Planning - Case Comments

Project Number: PR-2019-003210

Application Number: SI-2023-01118

Project Name: Cheddar's 10000 Coors Blvd NW

SITE PLAN

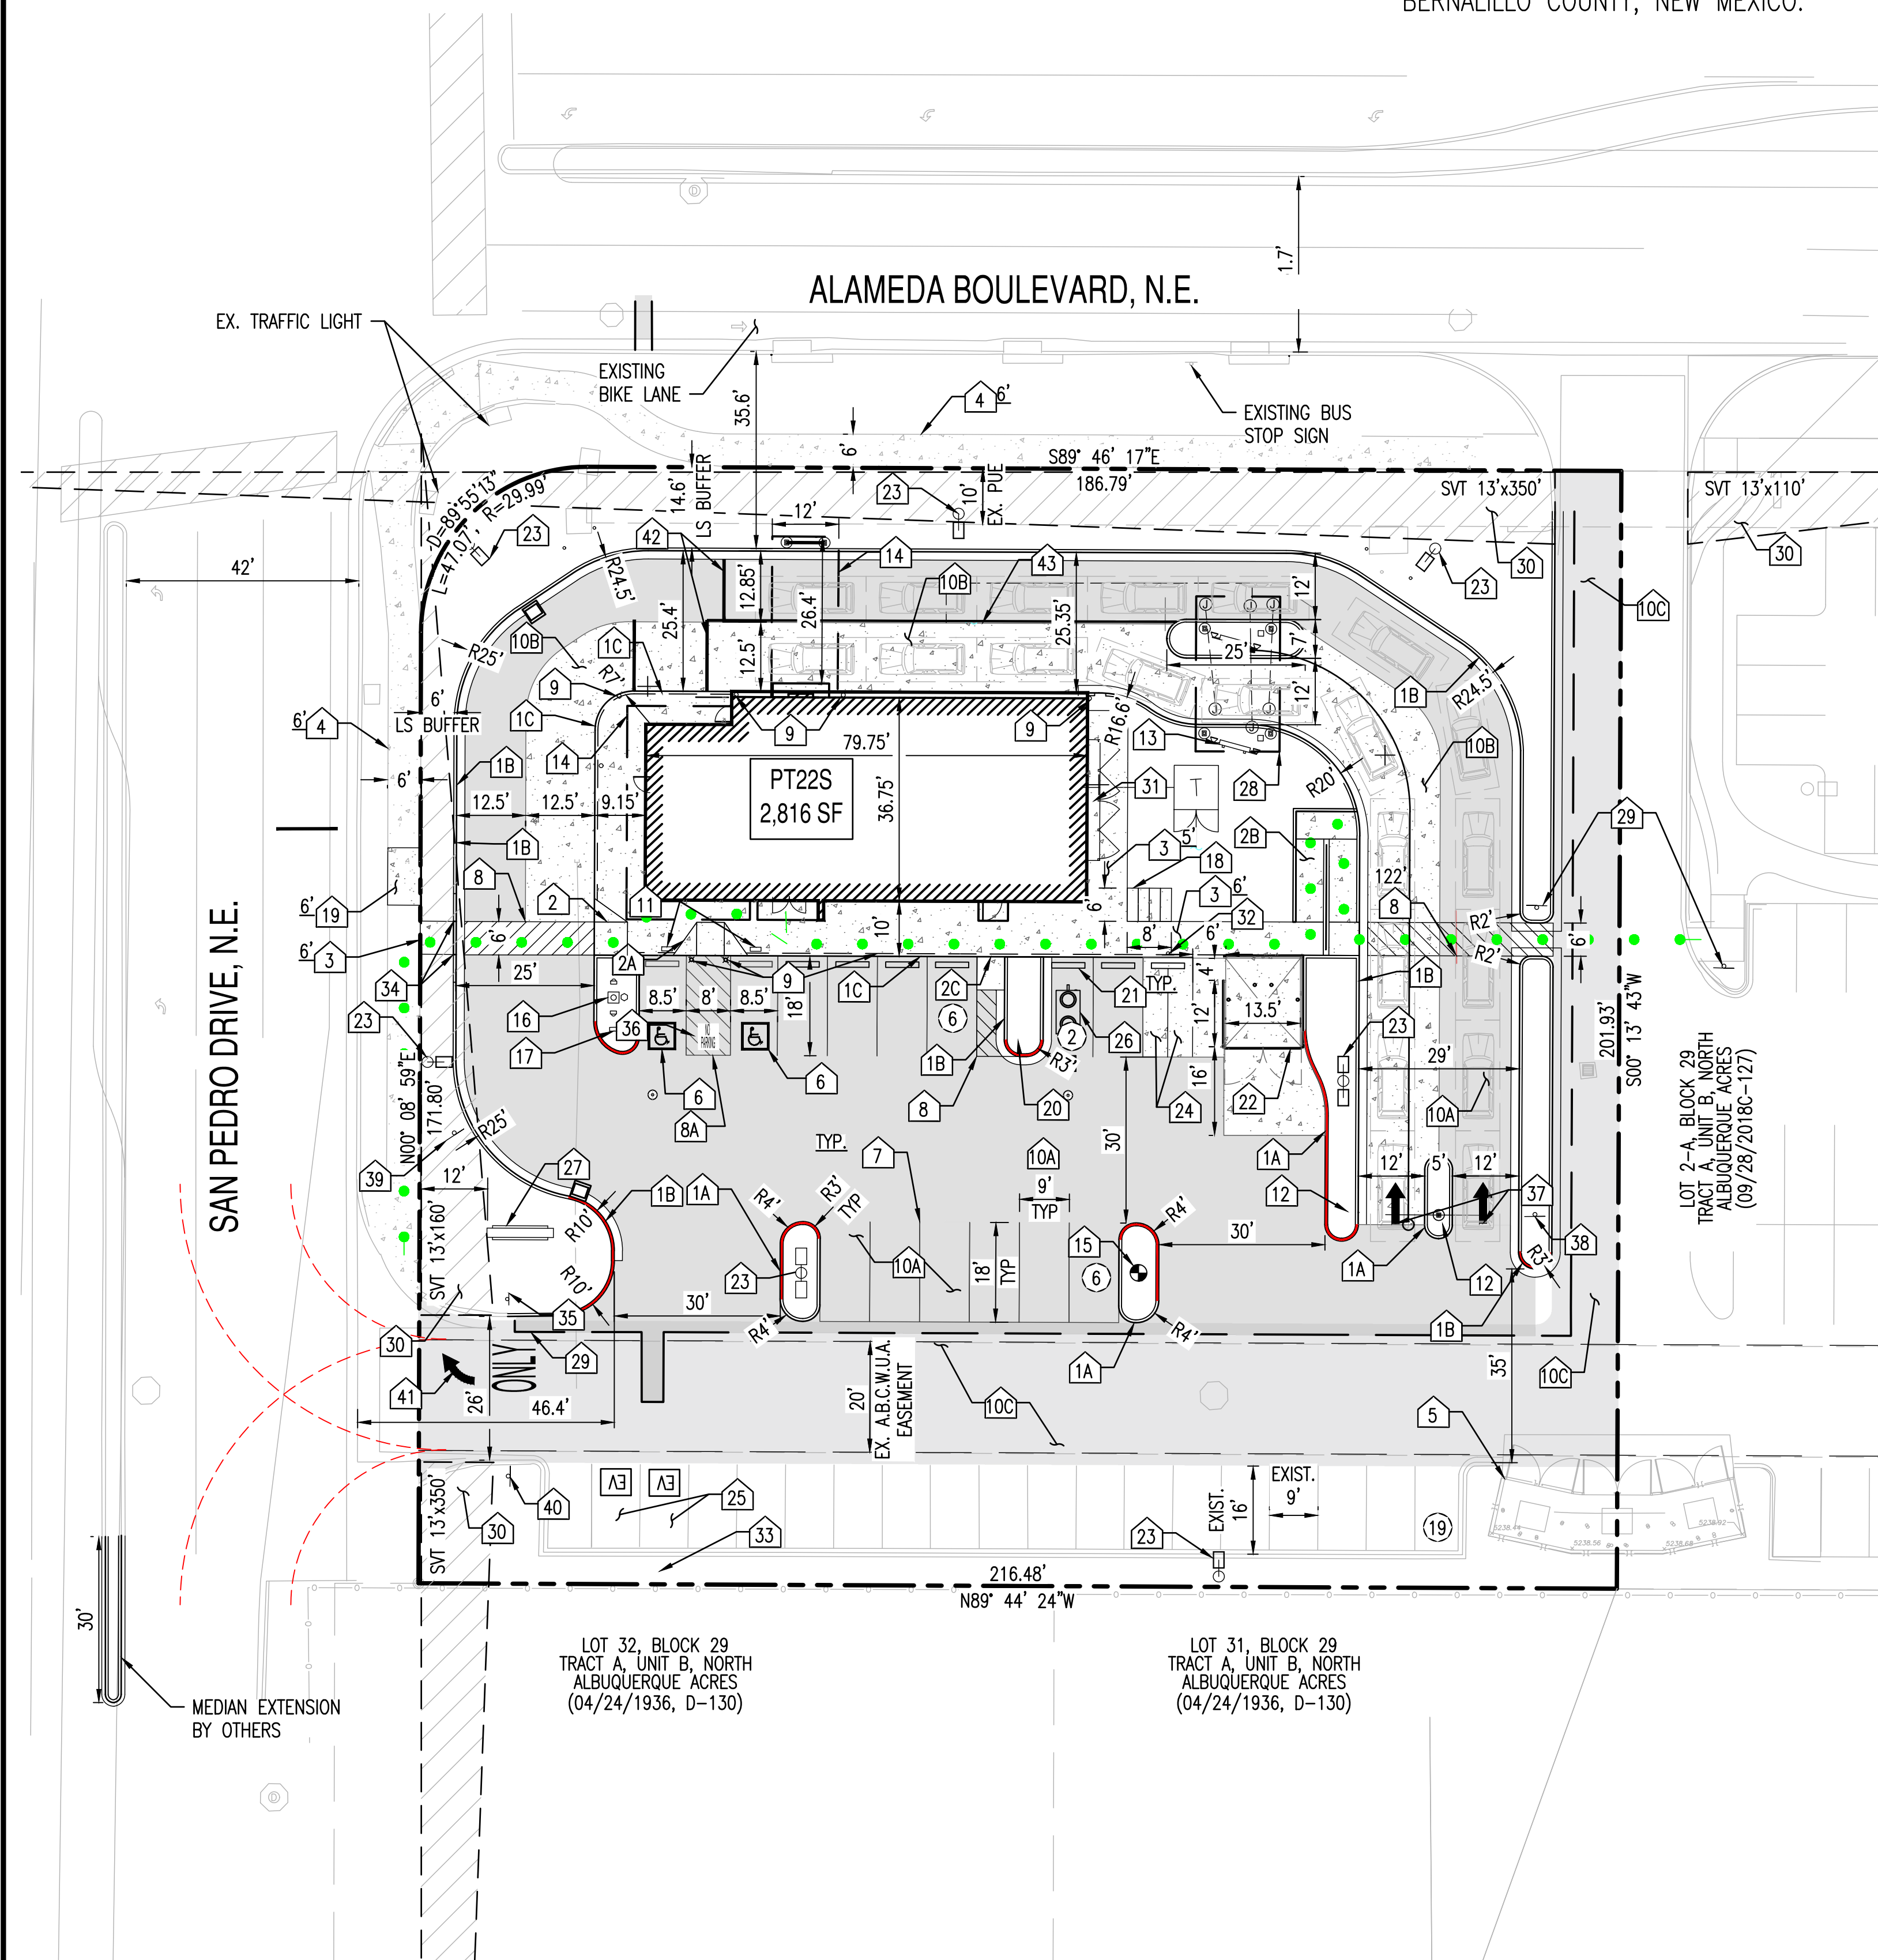
- Parking requirements per the **Cottonwood Mall Site Plan for Subdivision, freestanding restaurants are in accordance with the IDO.** Per the **IDO Table 5-5-1 Minimum Off-street parking**, 8 spaces per 1,000 SF are required. This site is within an employment center. Per the **IDO 5-5(C)(5)(a) General Reductions for Centers and Corridor Areas**, In UC-AC-EC-MS areas or in MT areas in Areas of Change, where Table 5-5-1 and Table 5-5-2 do not indicate a different

Parking requirements are not being met. Please confirm if there is a shared parking agreement with abutting lots, and check parking calculations for accuracy.

- Per Parking in the Cottonwood Mall Site Plan for Subdivision, **shared parking across parcel boundaries may be allowed pursuant to the provisions of a Reciprocal Easement Agreement between Parcels A, B-1-A, B-1-B, and B-2 through B-5. Total parking provided on all mall parcels combined shall be no less than zone code requirements for all combined uses.**
Please confirm if there is a shared parking agreement with abutting lots.

1 EAST ELEVATION 1
1/4" = 1'-0"
SIGN : 20 SF
FACADE: 658 SF
RATIO : 3%

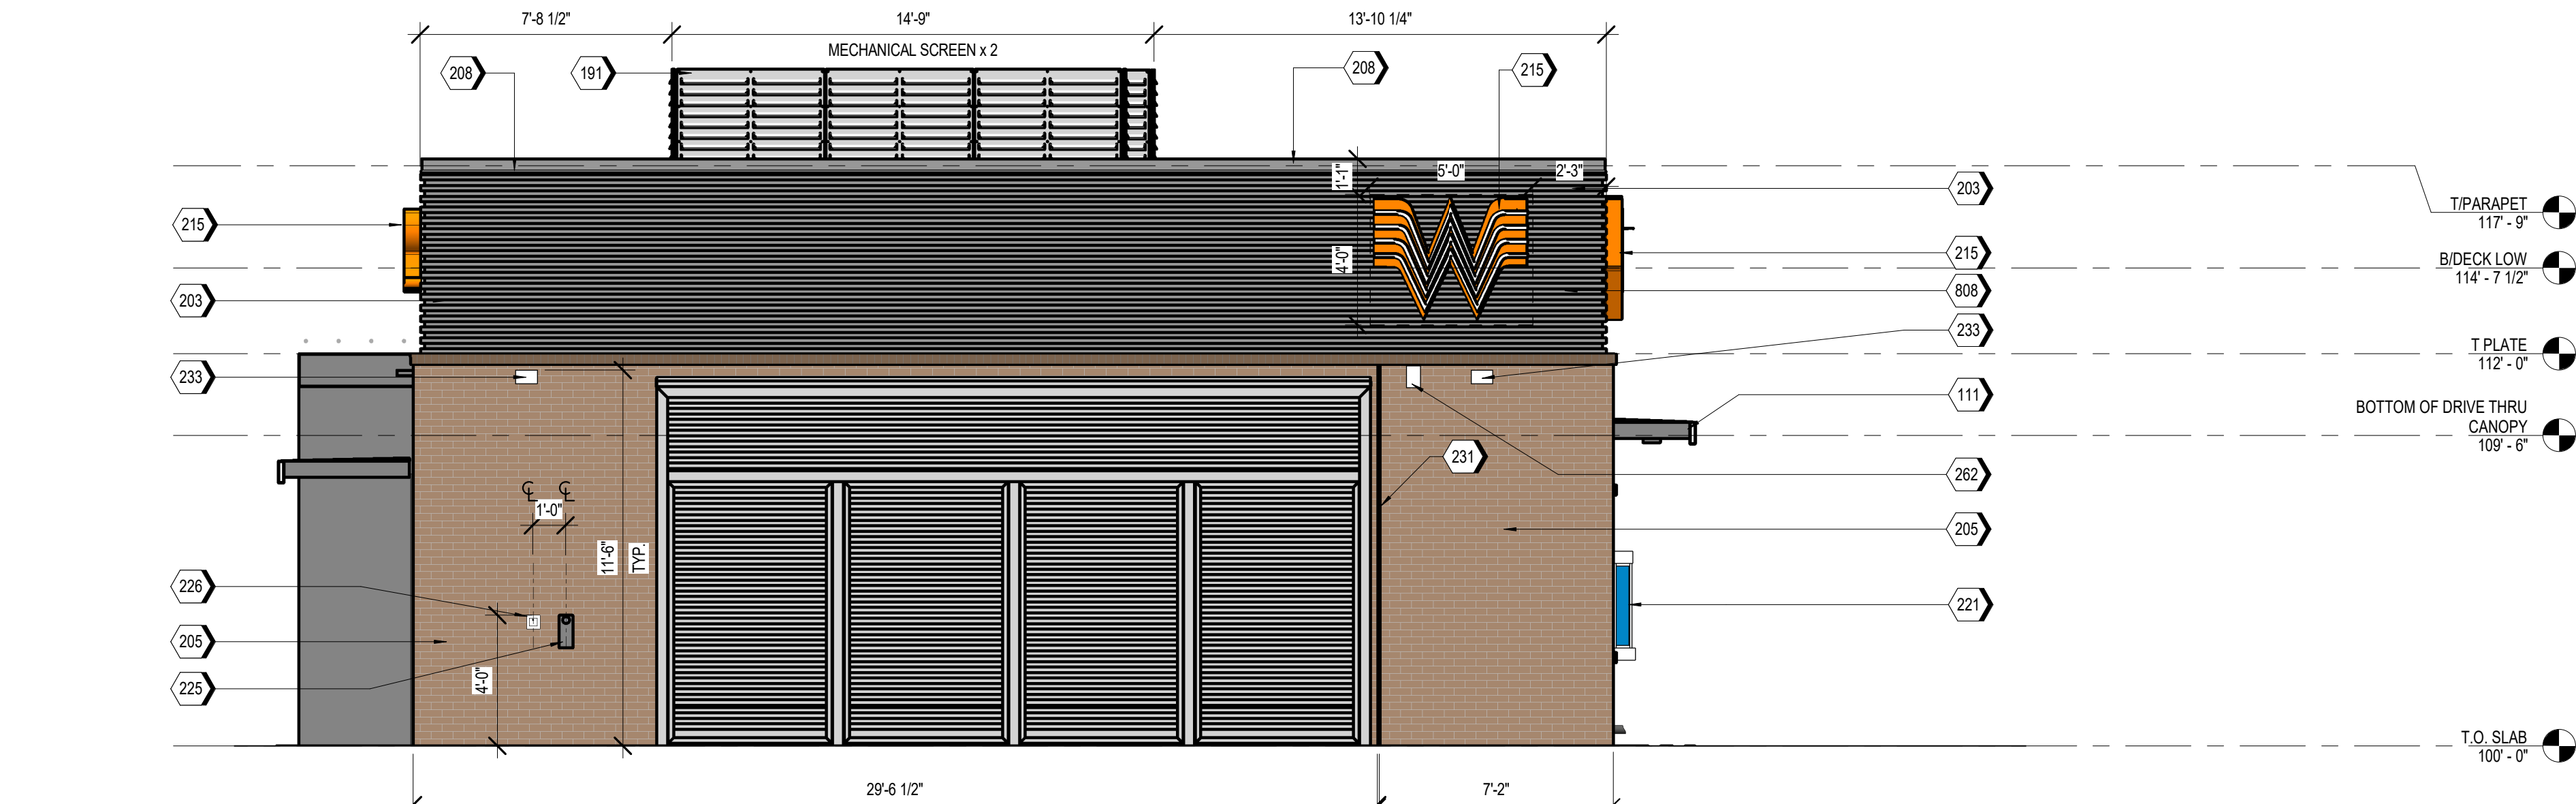
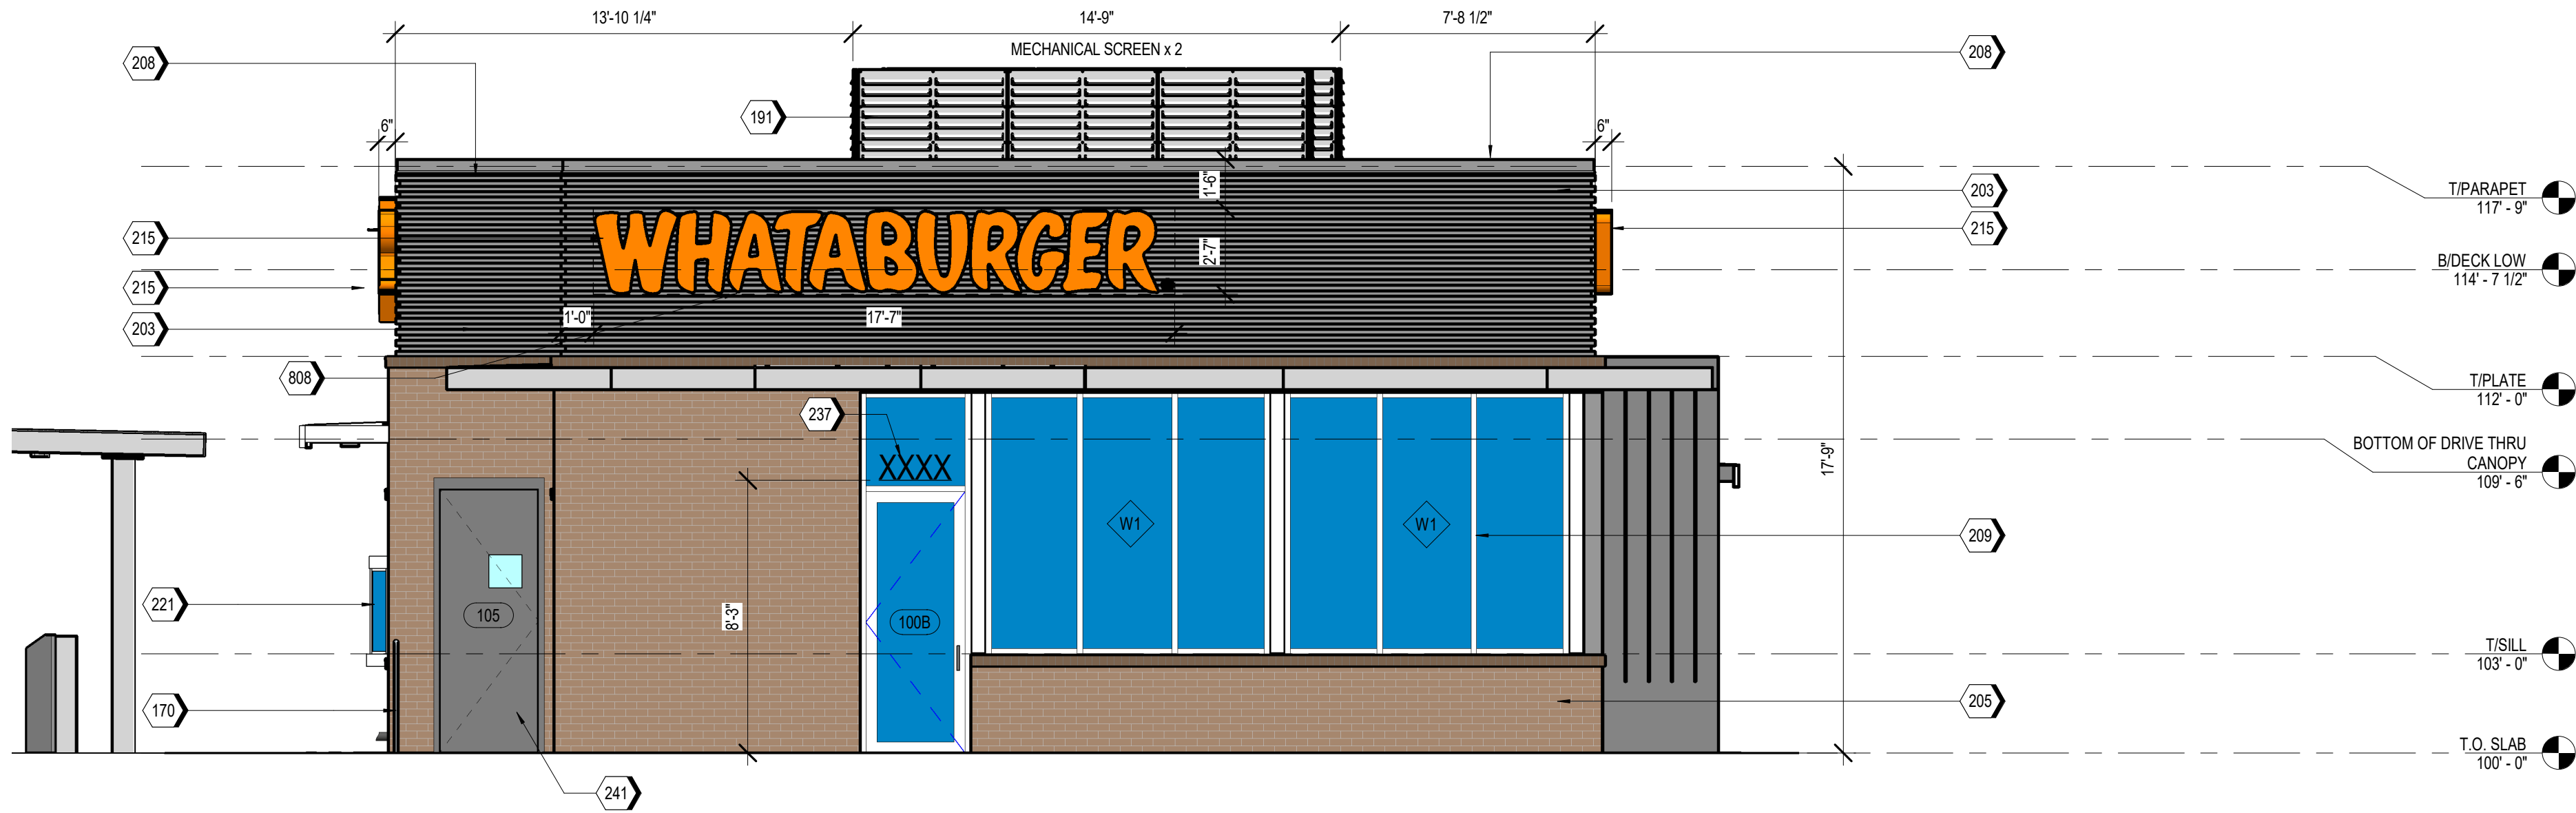
- Per the Cottonwood Mall Site Plan for Subdivision – **Signage; signs will be limited to 15% of the façade area and may be located anywhere within the area of that façade.**
On Color Elevation sheets Z5.1 and Z5.2, provide dimensions for sign and dimensions for façade. Façade is defined as the side to side dimension of the individual tenant space times the distance between the top of the building foundation and the top of the parapet.
